PM-18-00002

PREAPPLICATION CONFERENCE APPLICATION & MEETING SUMMARY

11. Proposed Project Name: Arena/Barn

**EXHIBIT A**

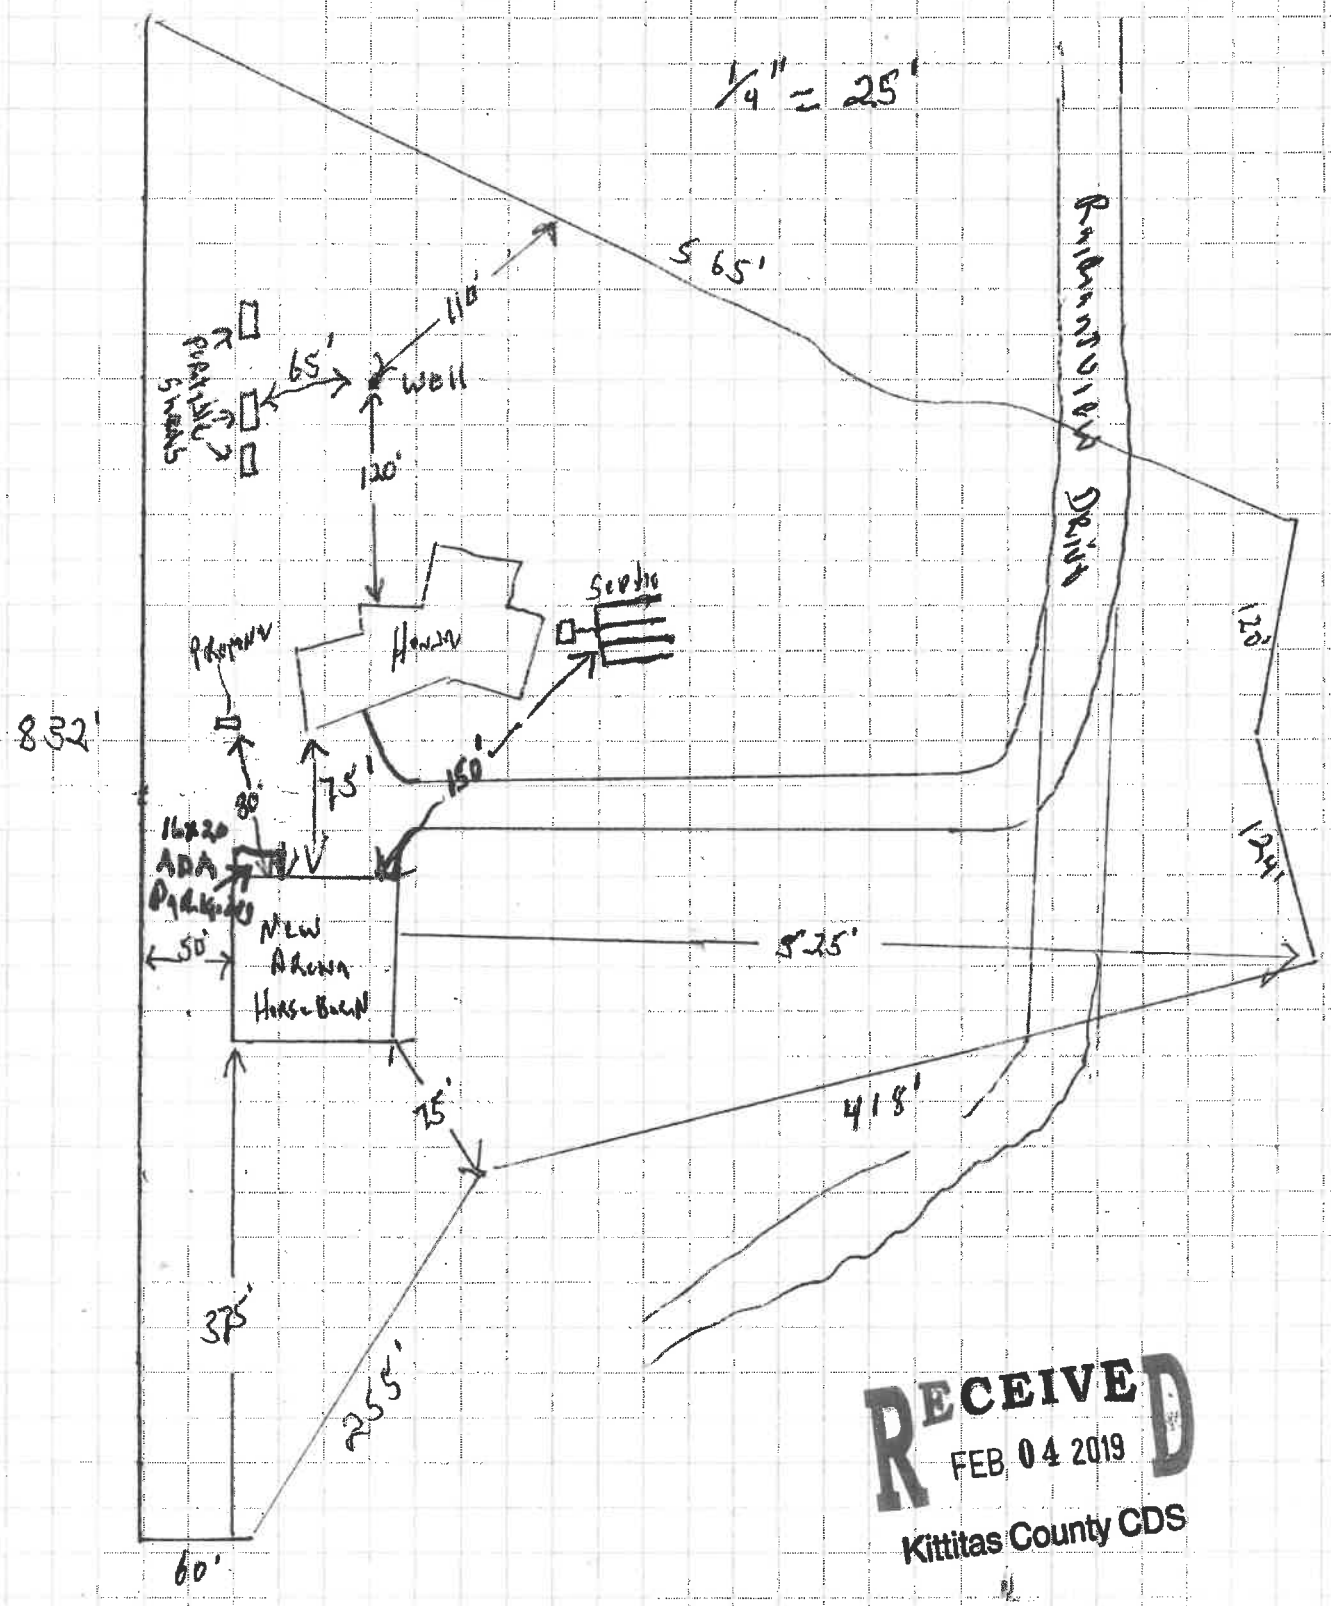
IF "A" OCCUPANCY, RESTROOMS, FIRE & LIFE-SAFETY, EGRESS, ACCESSIBILITY ARE REQUIRED TO BE IDENTIFIED & STAMPED BY A LICENSED ARCH. OR ENGINEER IT APPEARS THE PLAN PROVIDED DOES NOT CURRENTLY MEETS THESE REQUIREMENTS.
IF FOR PRIVATE USE THE PLAN IS ALMOST SUFFICIENT,

- Provide minimum 4" tall address numbers visible from the road.
- Provide all weather access, with a turn-a-round at least 16' wide.
- More information is needed on building use.

- Stormwater Plan - Eastern Washington Stormwater Manual
- Access will need to be checked to meet standards prior to building permit. If its currently to standard, no additional access permit required.

- Site evaluation needed to determine system to be installed
- size of system based on # of people using arena

→ flows need to be calculated.
